PHILIP GOACHER ASSOCIATES

Our Ref: PSG/sh/13177/001

Re: ~~135~~ & 135A WICK STREET, LITTLEHAMPTON

Drawing Title
Extension Scheme
Proposed Plans

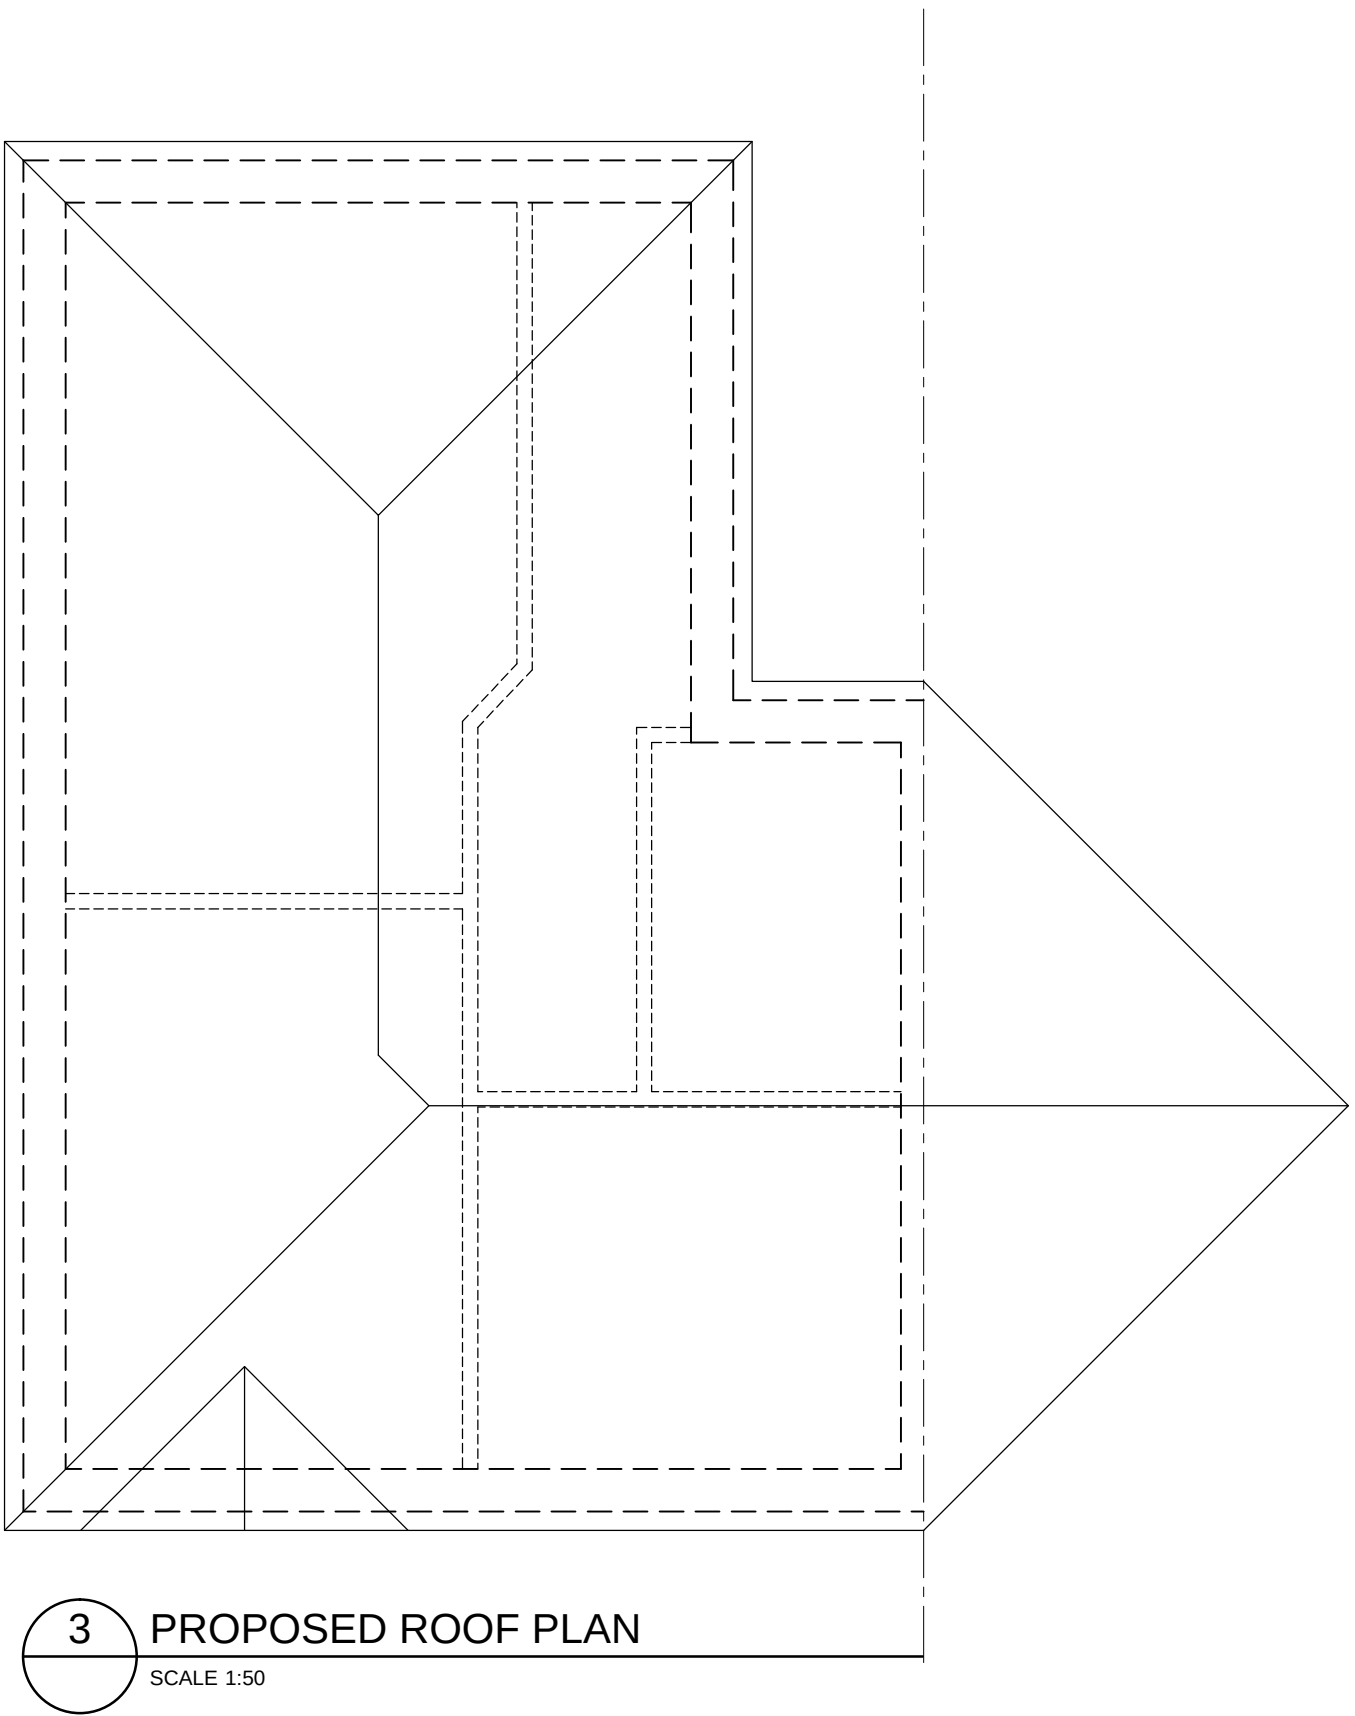
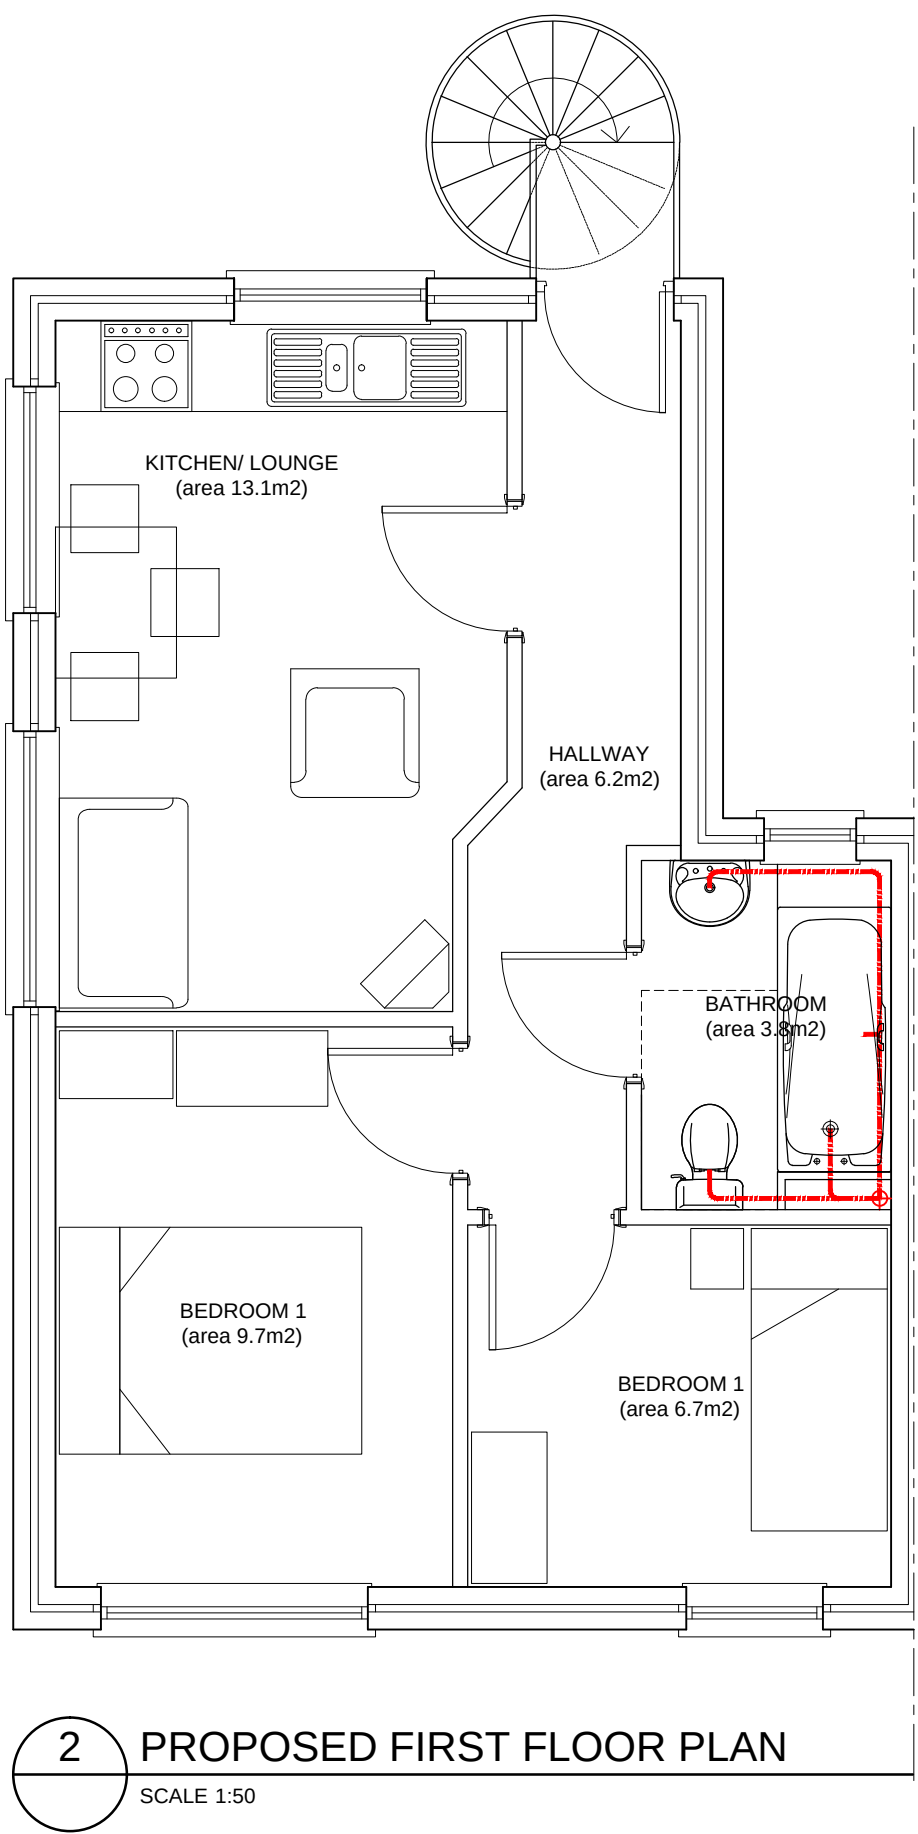
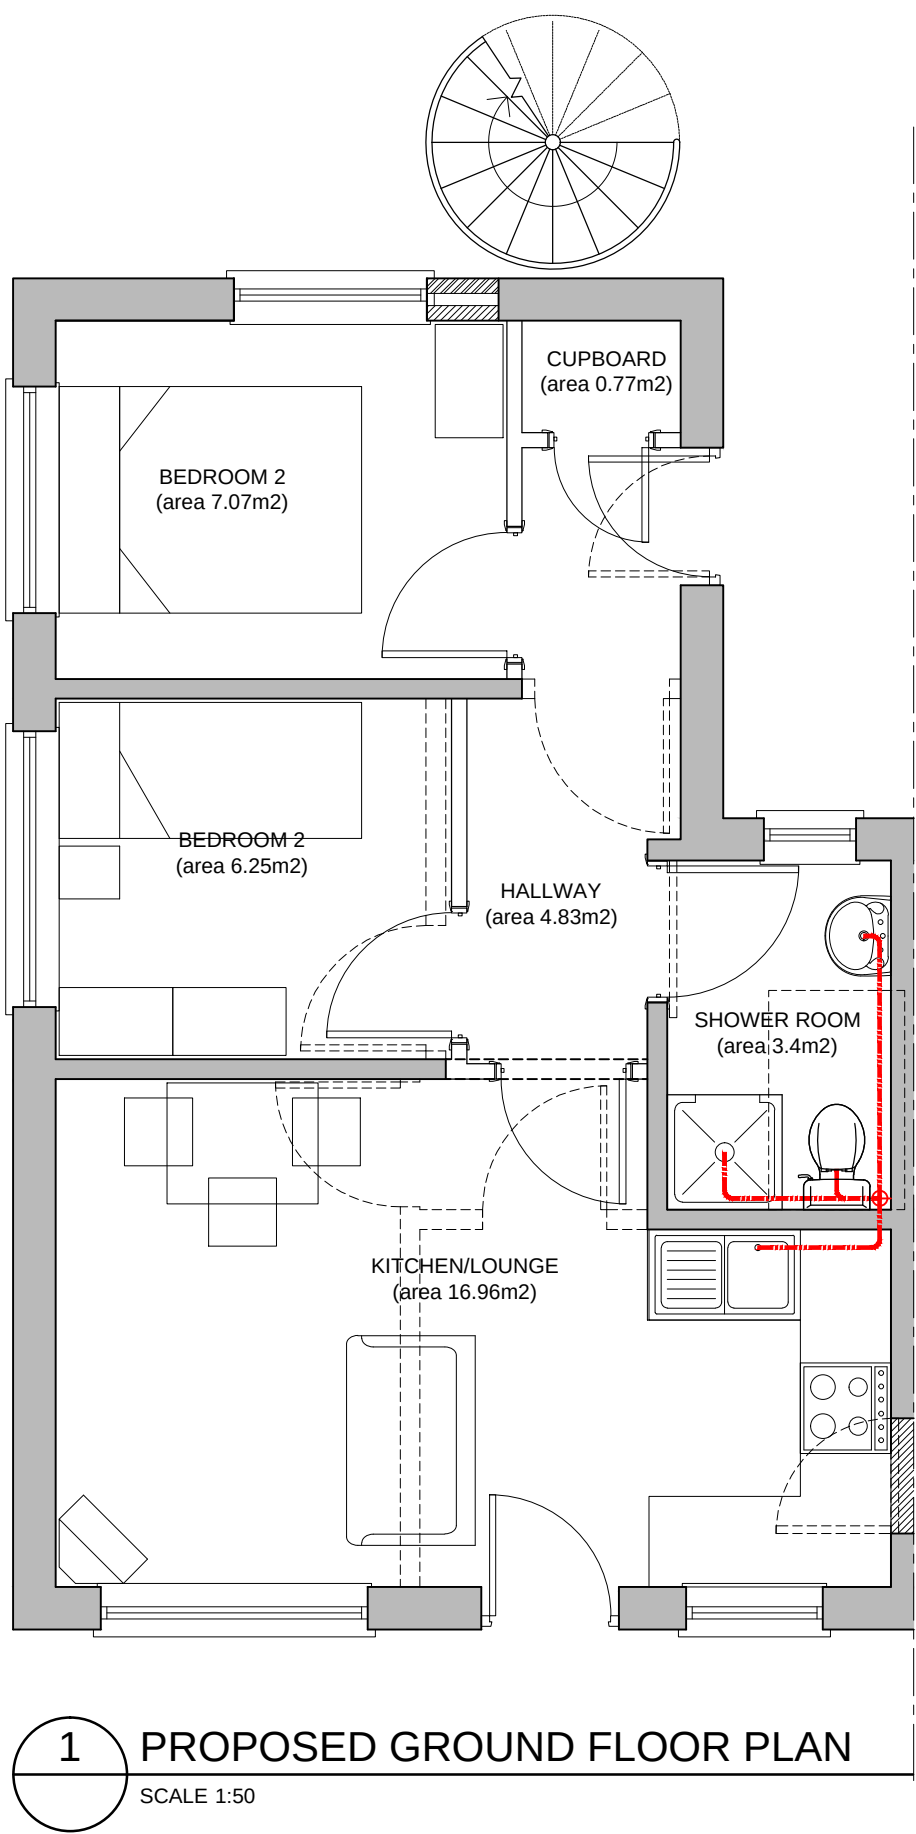
- 1.1 I understand from our conversations and the drawings received that it is proposed to construct a new first floor above the existing single storey building, with the new structure having a pitched roof linked into the adjacent roof of 135 Wick Street.

- 1.2 I have reviewed the proposals and confirm that I believe the additional storey extension will be possible and I have indicated what I believe to be the basic structural layout for the roof construction and first floor.

- 1.3 With regard to the roof, I have assumed that this will take a traditional cut and pitched timber construction bearing onto new steel beams at ceiling level, rather than a trussed rafter roof construction. This is try to spread the roof load evenly around the loadbearing walls in order to avoid overloading certain areas of the existing structure, potentially leading to a requirement for localised underpinning.

- 1.4 With regard to the first floor structure, it is likely the existing flat roof joists will not be adequate to act as floor joists, however, this can be reviewed and
